Subject: RE: SUB PLAN REQUEST - FW: Land at Bilsham Road - Y/155/20/DOC, discharge of condition 15

Subject: Land at Bilsham Road - Y/155/20/DOC, discharge of condition 15

Regarding condition 15, both our Environmental Health Officer and our Ecologist comment that there is no lighting scheme for them to consider. In particular, our ecologist states that:

BILSHAM ROAD, YAPTON			
Drawing Title: PRELIMINARY ENGINEERING LAYOUT. SHEET 2 OF 2			
Client: BILSHAM ROAD DEVELOPMENT LLP			
Scale: 1:500 @A0	Date: FEB 20	Designed: NA	
Drawn: LS	Checked: JH	Approved: GG	
Job No: 19-326	Drawing No: 19-326/010	Rev: J

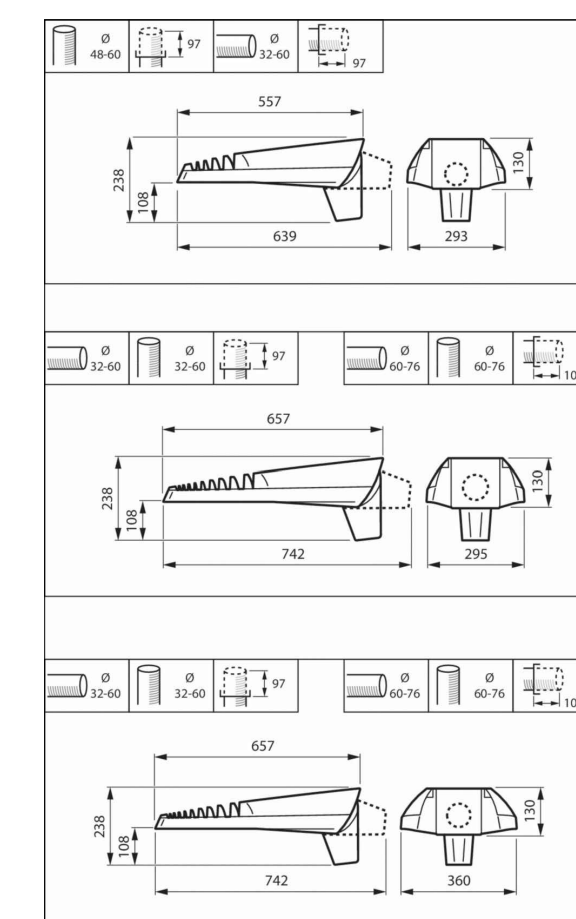
Our ecologist is happy with the street lighting but states that there is still no information on lighting on the houses and this is required to complete the assessment. Please supply by the 10th February so I can reconsult.

"Please can further information relating to the lighting scheme onsite be submitted with this application, including the details of the chosen light fittings for both external site lighting but also the external lighting on each property along with their locations. The information provided on the preliminary engineering layout is not sufficient. The application should be aware that the lighting will need to ensure there is no light spill towards any roofs, hedgerows and trees as this would disturb any foraging or roosting bats."
